**WEST SUSSEX COUNTY COUNCIL
PLANNING SERVICES CONSULTATION**

SUBJECT: Y/40/17/OUT-Outline application with some matters reserved (access only) - erection of 34No. dwellings with access from Hoe Lane, Flansham. This application affects the setting of a Listed Building. This application is a Departure from the Development Plan.

Bonhams, Hoe Lane, Bognor Regis, West Sussex, PO22 8NP

Visibility Splay 2.4m x 43m

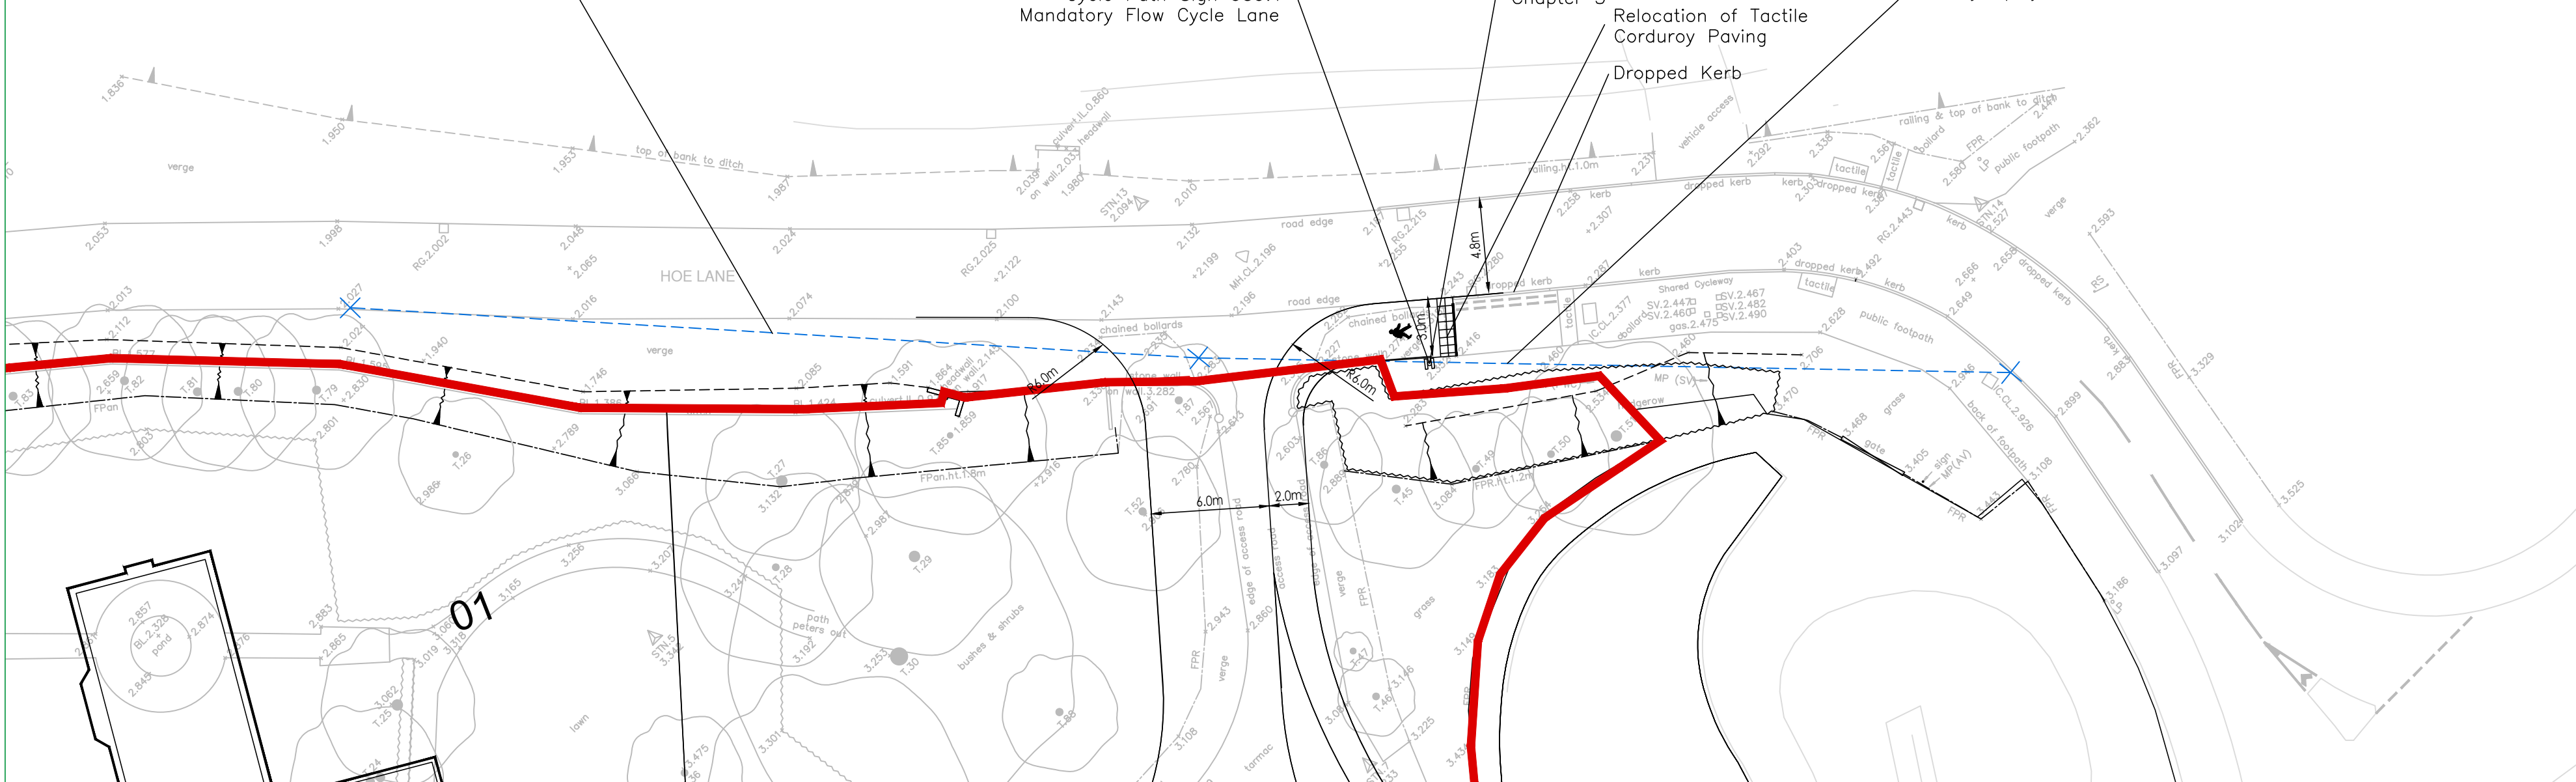
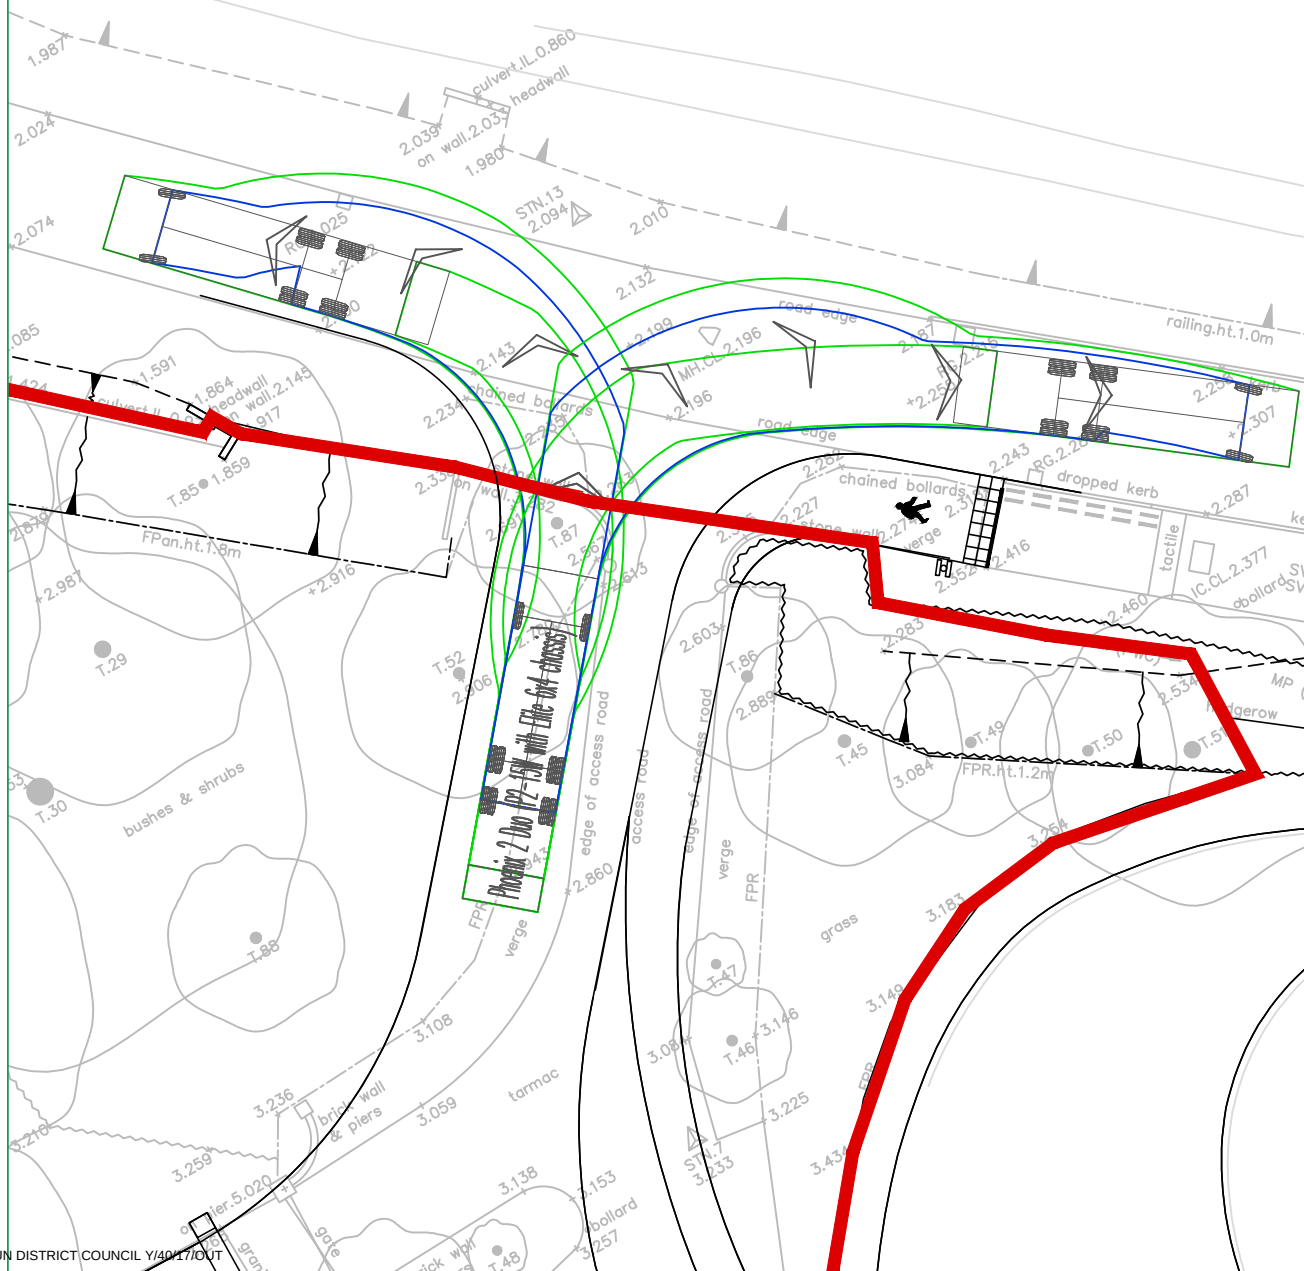
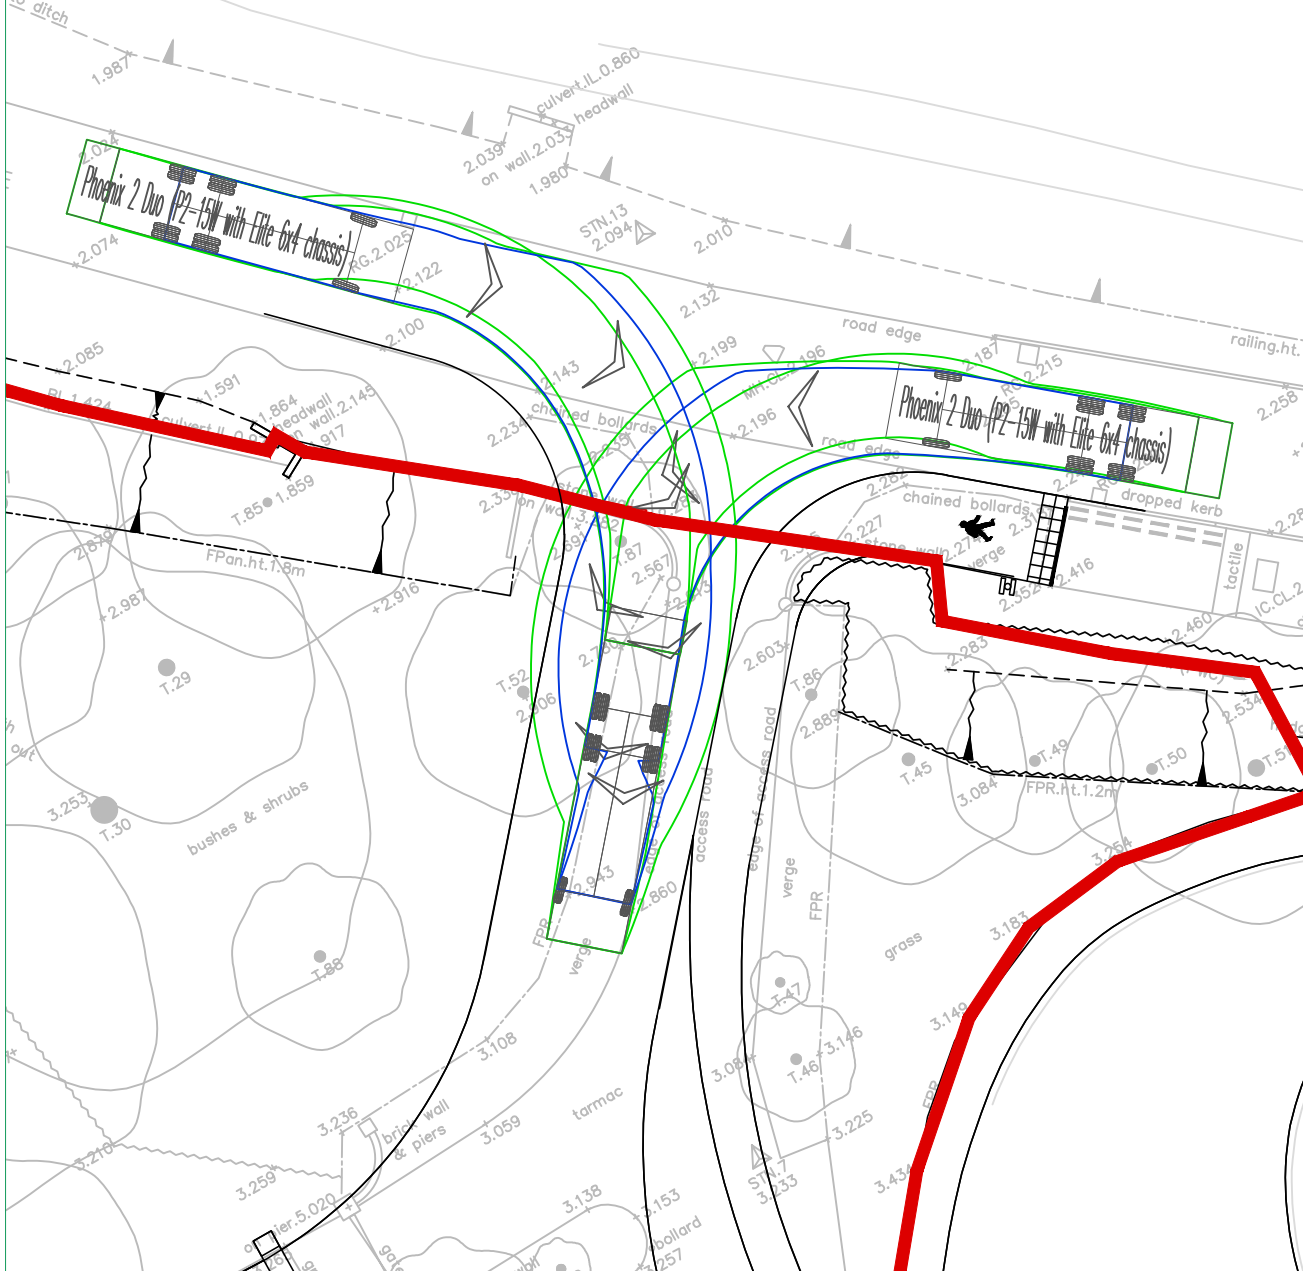
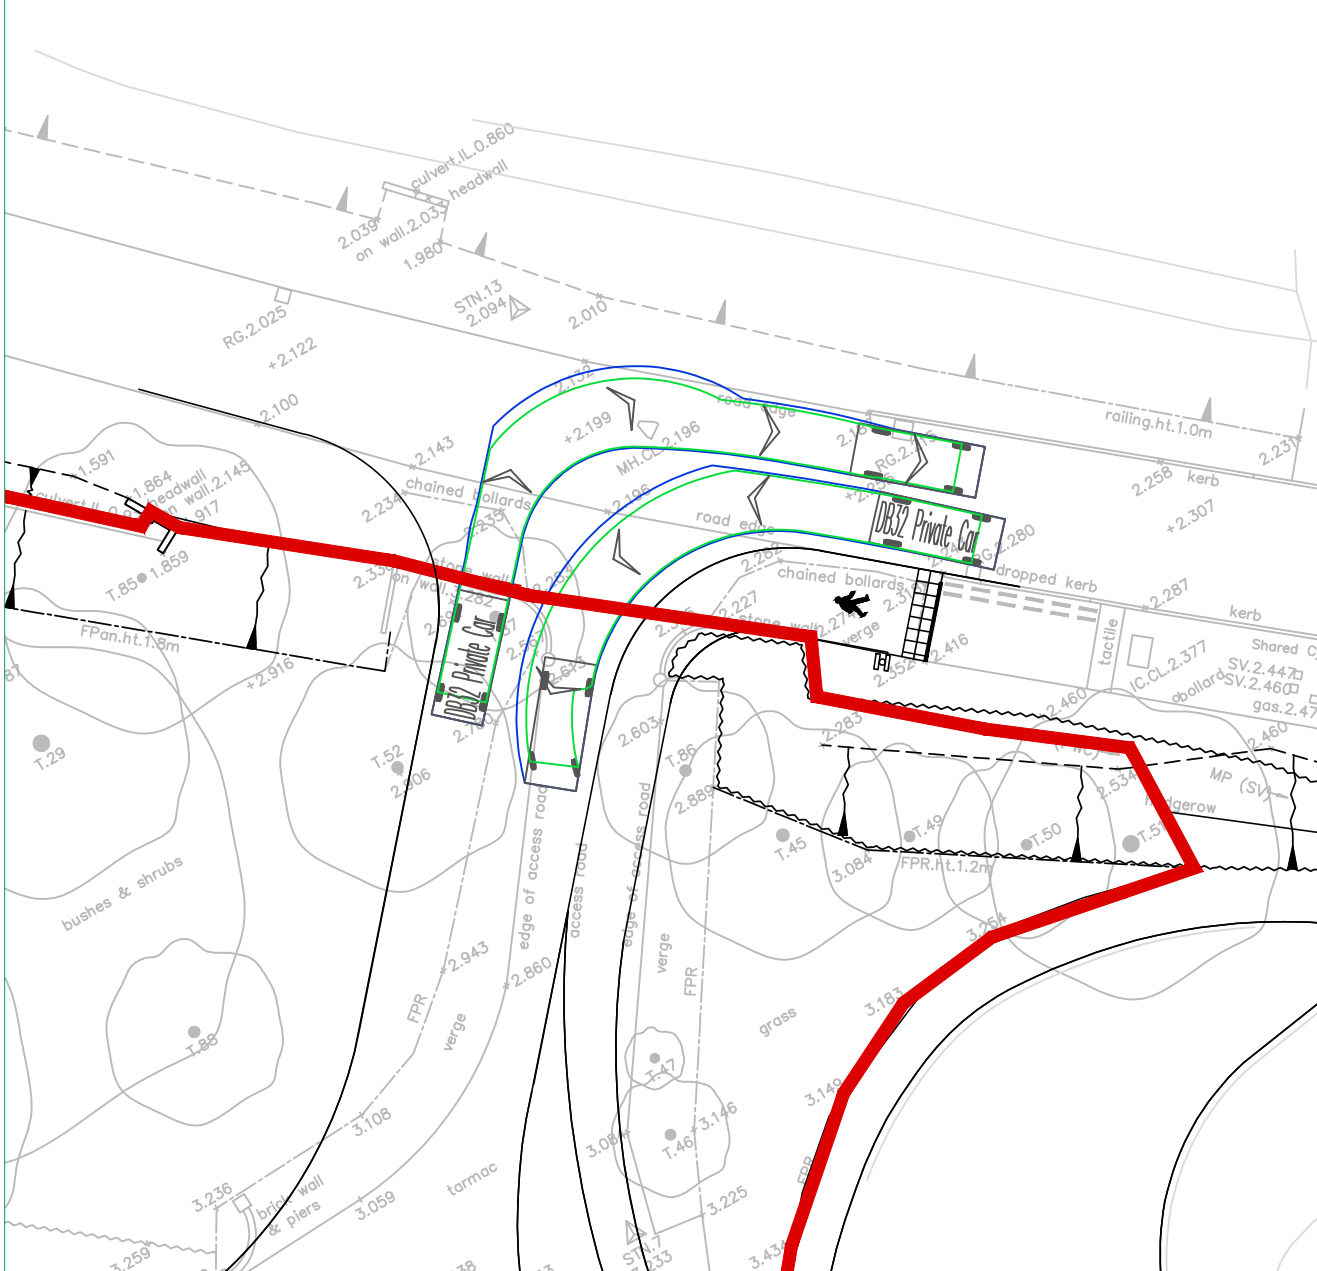
Problem-3.4-The Auditor notes that there is a risk of cyclists running into the footway and into the site. It is advised that the proposed footway extension works may need to be reviewed to include appropriate relocation of the existing corduroy tactile paving to make pedestrians aware of the shared surface conditions and also to incorporate suitable signing and narrow marking guides. The Designer has responded and agrees with the Auditors recommendations and confirms that this can be discussed further at the detailed design stage of the application.

The visibility splays have been based upon 85th percentile recorded by ATC surveys. Speeds of 23.5 mph and 22.8 mph have been recorded onto Hoe Lane. However with the trimming of vegetation, the applicant has demonstrated that visibility splays of 2.4 by 43 metres are achievable in both directions. These sightlines are in accordance the requirements set out within Manual for Streets (MfS) and exceed the splays required for the recorded speed limit from the ATC surveys. Taking account of local context and traffic flows, the LHA consider that MfS guidance is appropriate in this instance. As such, this junction is considered to be adequate to accommodate the vehicular movements arising from this proposal.

Whilst it is acknowledged that permission for the sites layout is not sought, there are no initial concerns with the indicative layout. The access road will take the form of a 6.0 metre wide shared surface arrangement with 8 metre kerb radii. This is considered suitable as this will be a low speed, low traffic environment. MfS2 identifies that shared space is appropriate where vehicles flows are less than 100 per hour, the proposal would meet this criteria. Refuse collection will take place from within the site. Swept path diagrams have been provided showing larger vehicles turning paths within the site. The applicant should liaise with ADC's Waste Collection Team to discuss the suitability of this arrangement from their perspective.

No part of the development shall be first occupied until visibility splays of 2.4 metres by 43 metres to the south have been provided at the proposed site vehicular access onto Hoe Lane in accordance with the approved planning drawings. Once provided the splays shall thereafter be maintained and kept free of all obstructions over a height of 0.6 metre above adjoining carriageway level or as otherwise agreed.
